PL- Consultation- Conservation Officer response

Subject: AB/155/25/HH

Address: 15 Maltravers Street Arundel BN18 9AP

Proposal: Ground floor rear bay window extension.

EXISTING GROUND FLOOR

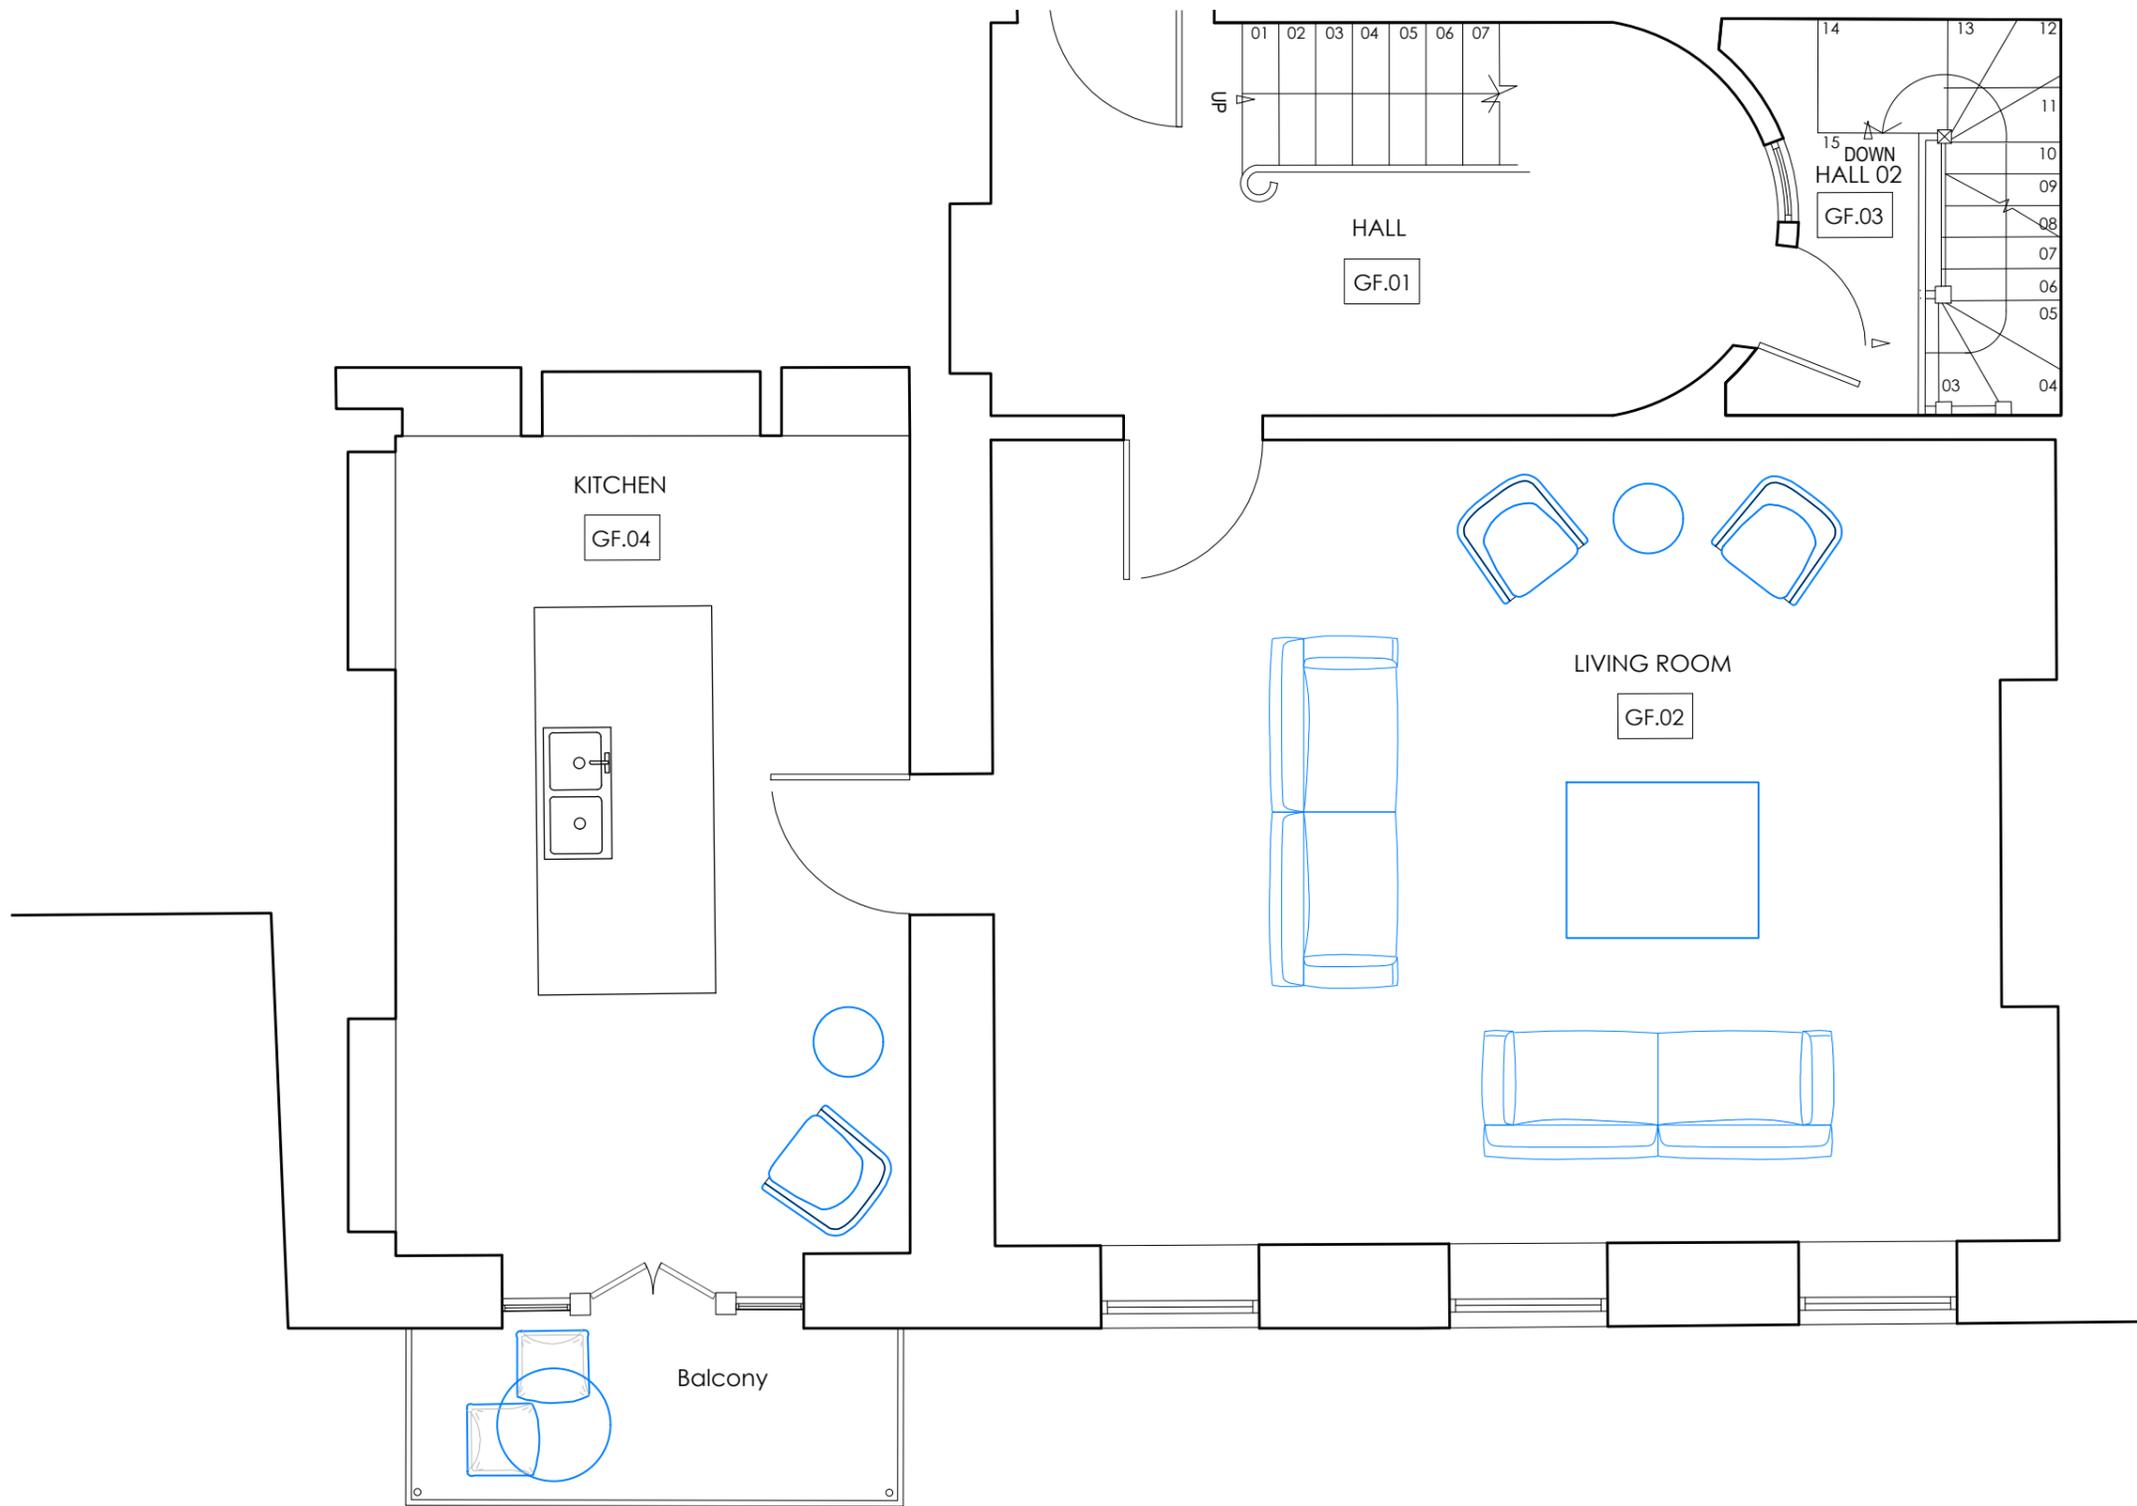
The proposal is to remove the existing covered balcony and replace it with a larger enclosed structure. We are informed that the new enclosed space will provide a dining space off the rear of the kitchen at the (raised) ground floor level.

The existing balcony is a simple design, and we are informed that it was constructed in 1998 as part of a programme of works to the listed building. The design reflects the simple rear elevation of the house and is set to one side of the oldest part of the building so that element remains clearly visible. Its design is also such that the C.19 element is still visible.

PROPOSED BASEMENT

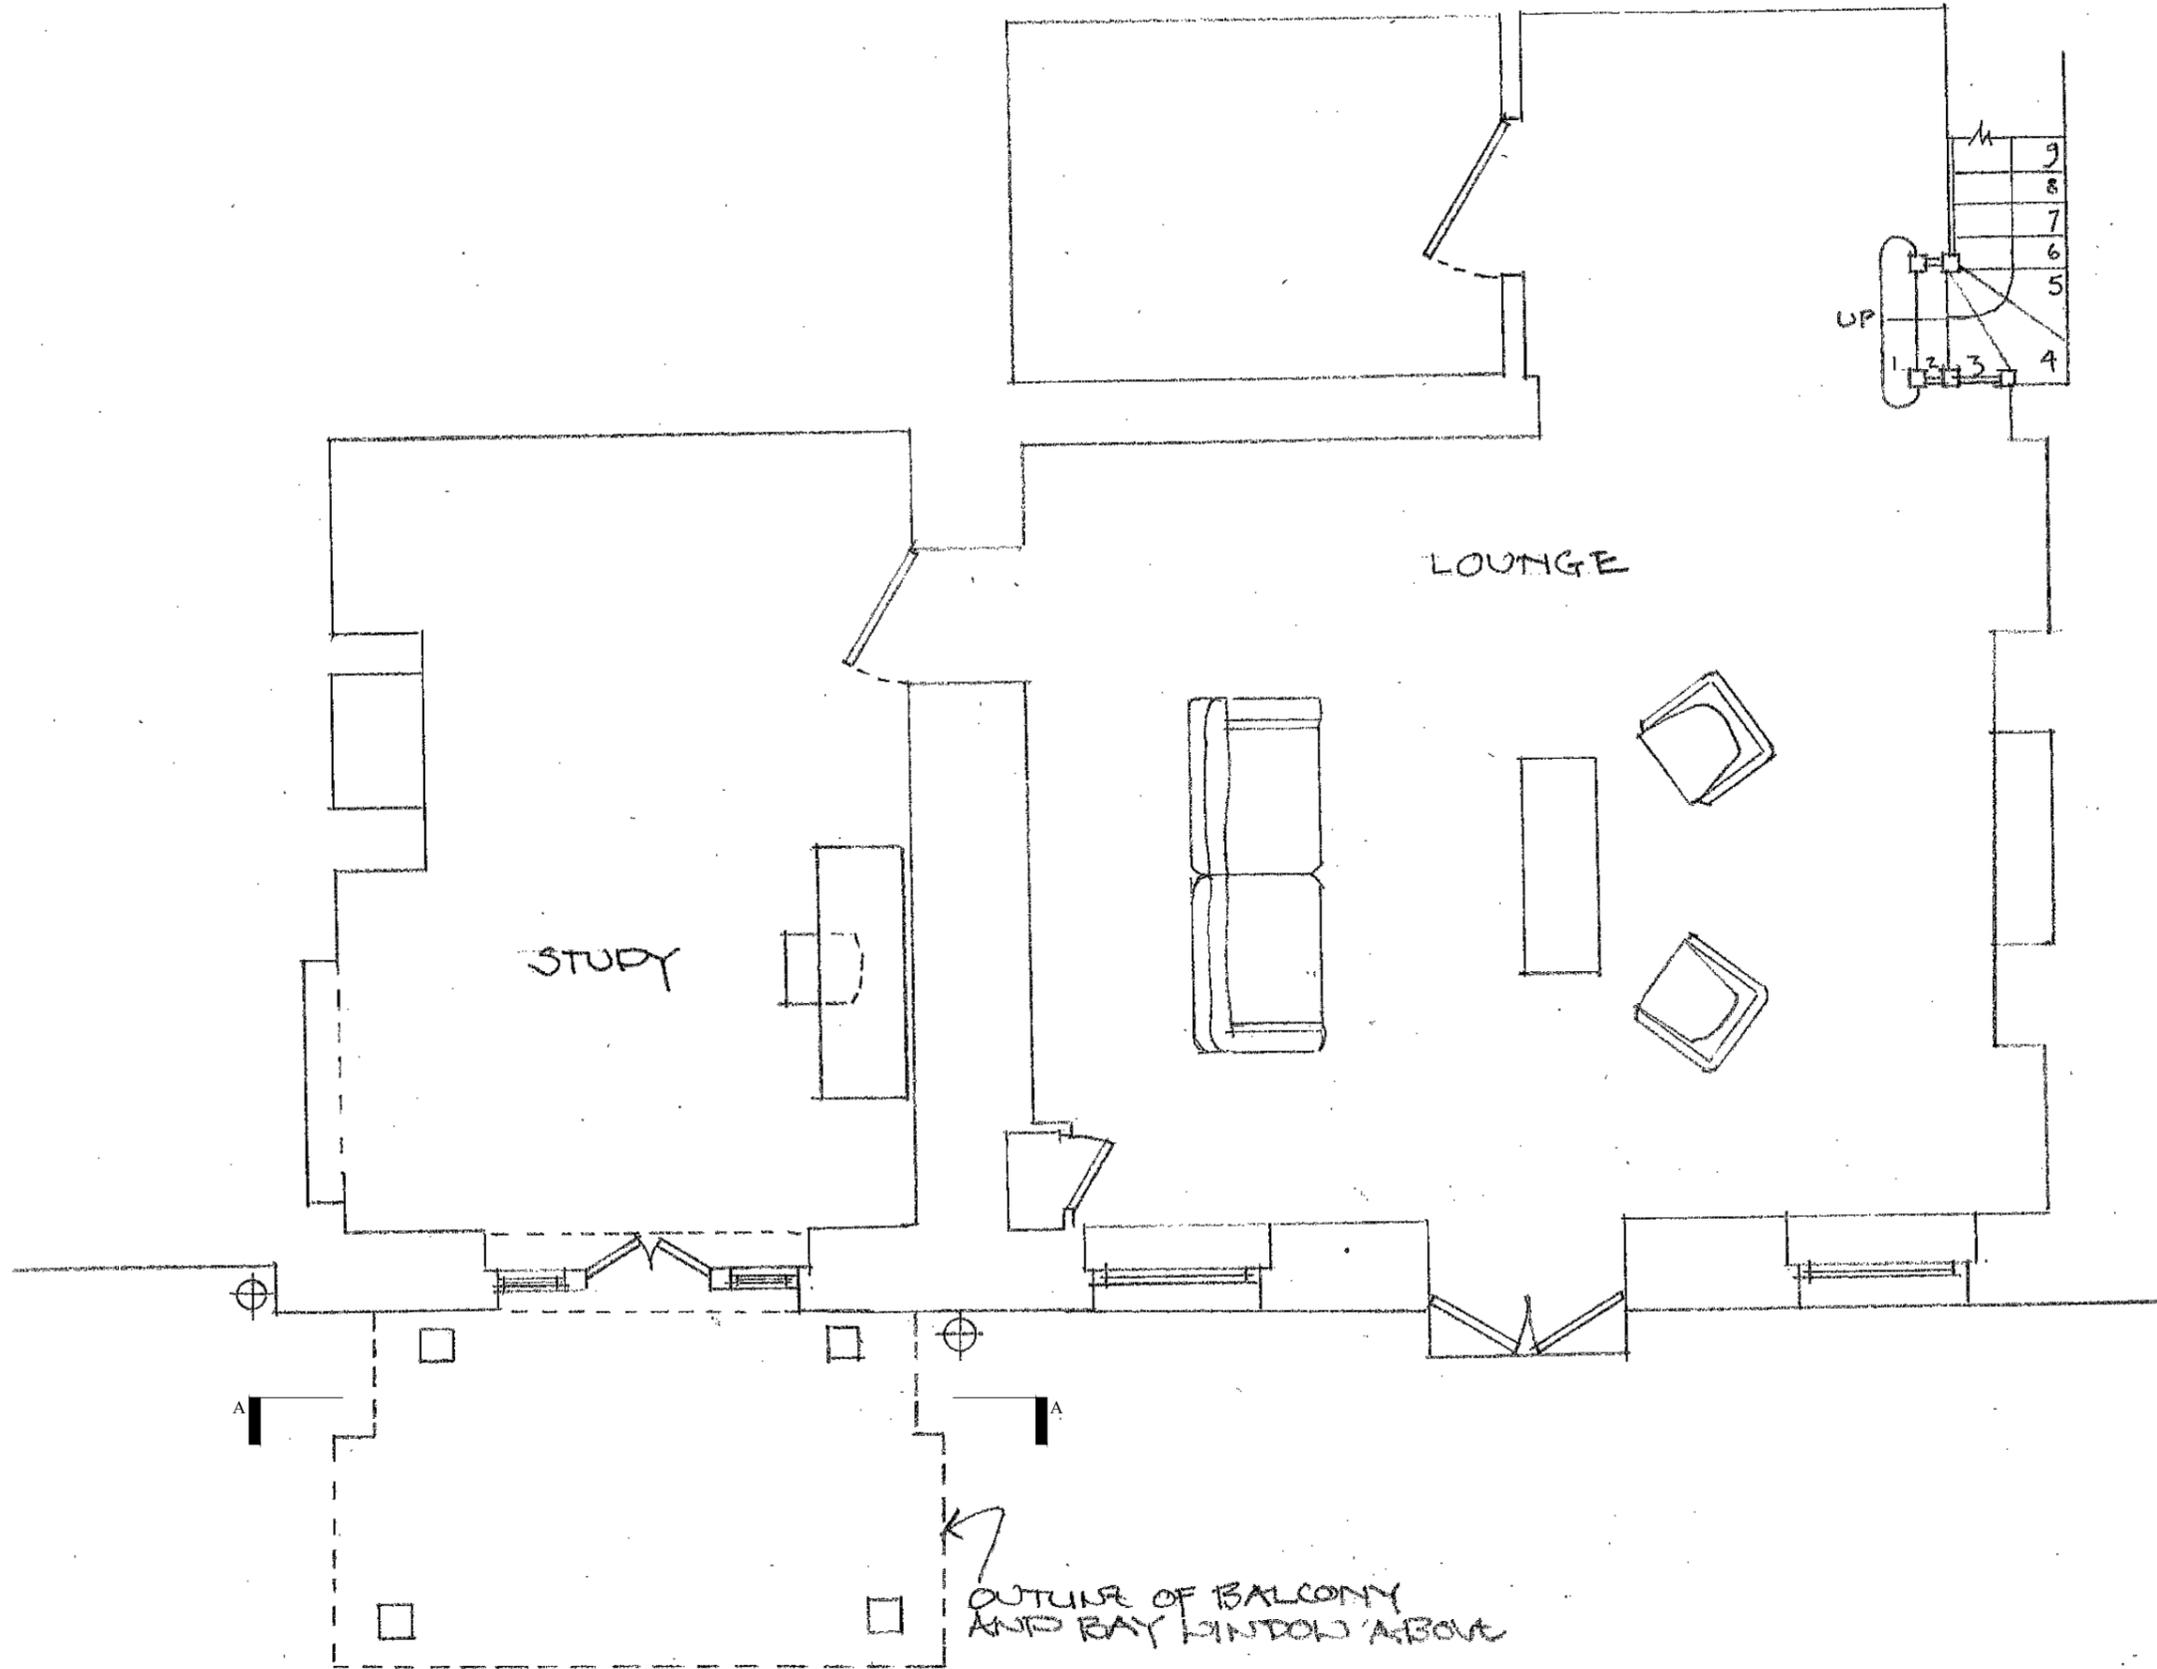
The replacement structure appears to take cues from the existing modern covered balcony but would project almost a further 2 metres outwards. It would also be fully enclosed for all-weather use. The current application represents a revised design and would appear to have addressed previous concerns to the extent that it can now be considered to have a neutral impact on the listed building and the conservation area. I should point out, however, that this is subject to the

submission of further information regarding the detailed design of the windows, doors, railings and columns.

Prior to their insertion details of the windows and doors including their design/appearance (including elevation), specification, glazing bars, glazing (system), method of opening, decorative/protective finish (i.e. stain/paint and colour) and location within the reveal, in the form of drawings and sections of an appropriate scale, shall be submitted to and agreed in writing by the Local Planning Authority before the windows and doors are installed.

Appropriately scaled details of the new railings and columns hereby approved shall be submitted to the Local Planning Authority and approved in writing. Details shall include the design of the railings which shall be drawn at an appropriate scale.
